Subject: Prior Notification Of Works To Tree(s) In A Conservation Area - WA/10/21/TC

Application ref: **WA/10/21/TC**

Location: The Coach House, The Street, Walberton, BN18 0PJ

THE COACH HOUSE, THE STREET WALBERTON

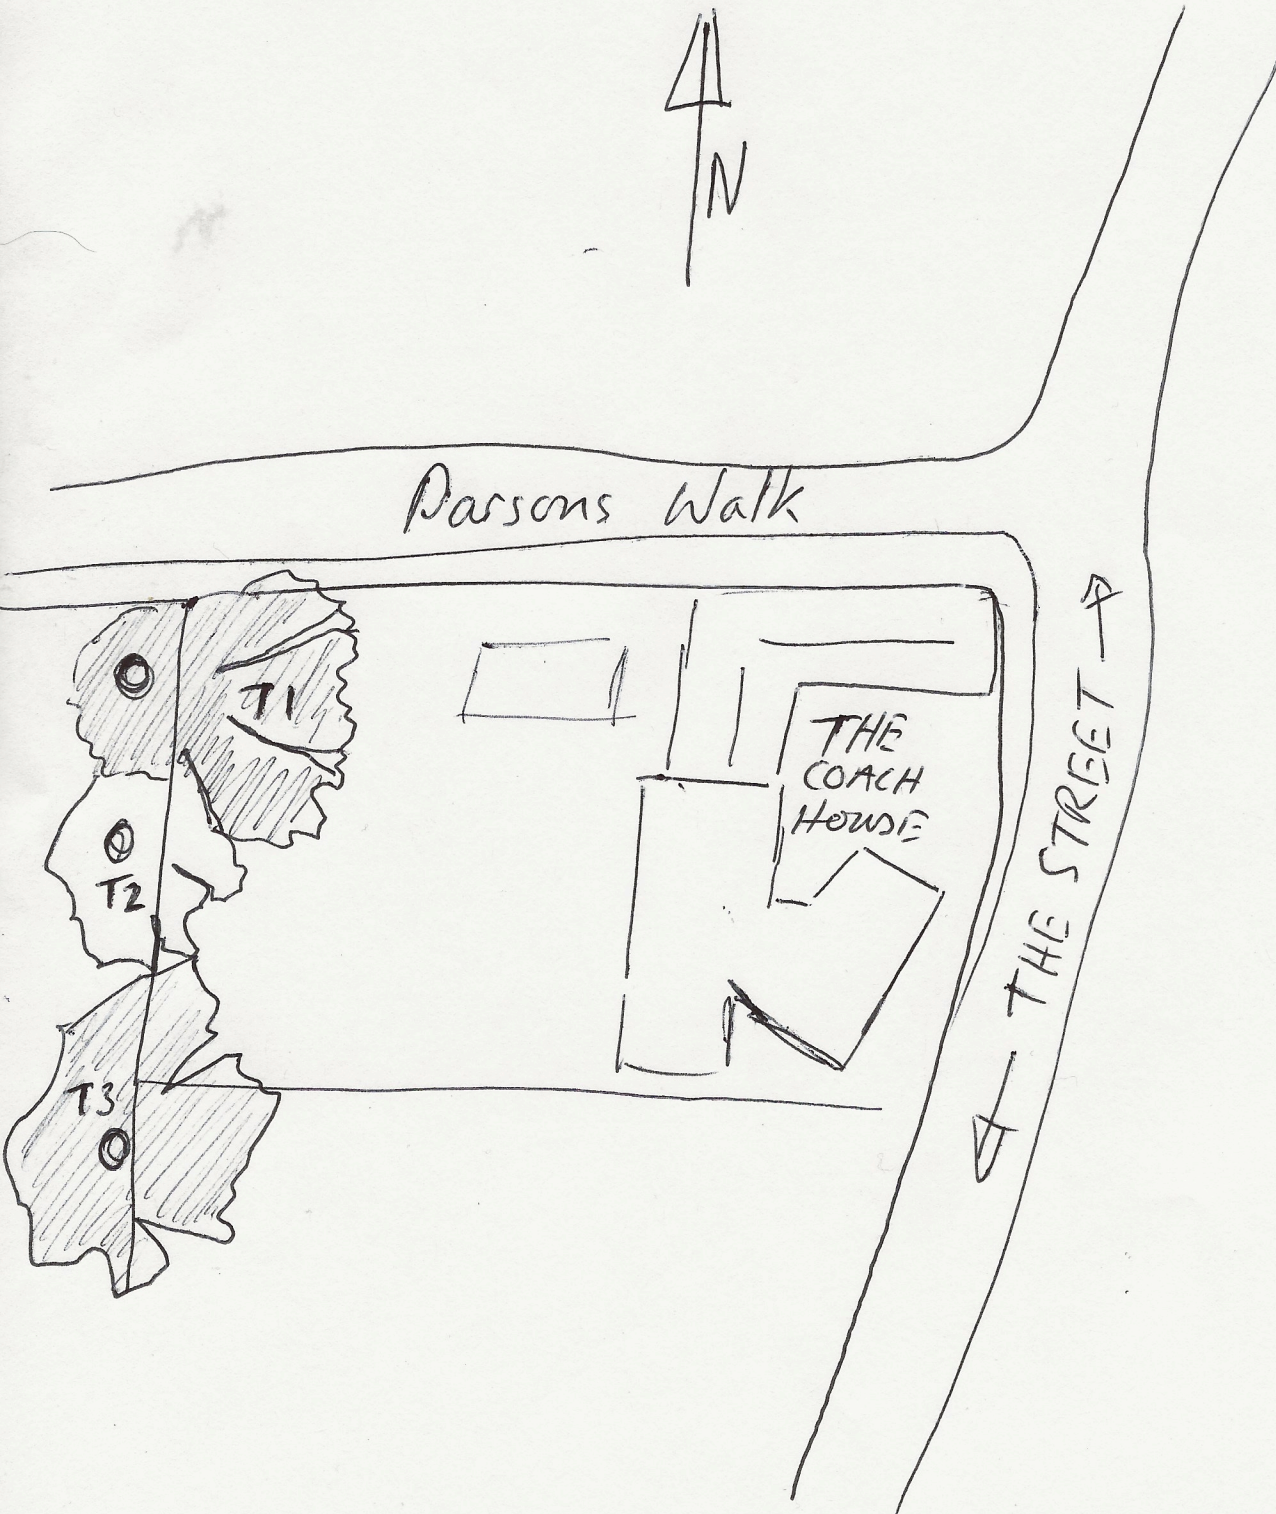
Although clearly illustrated on the submitted sketch plan, and T1 being indisputably 'the oak' – it is for the sake of absolute clarity a Turkey oak and not a red oak as described.
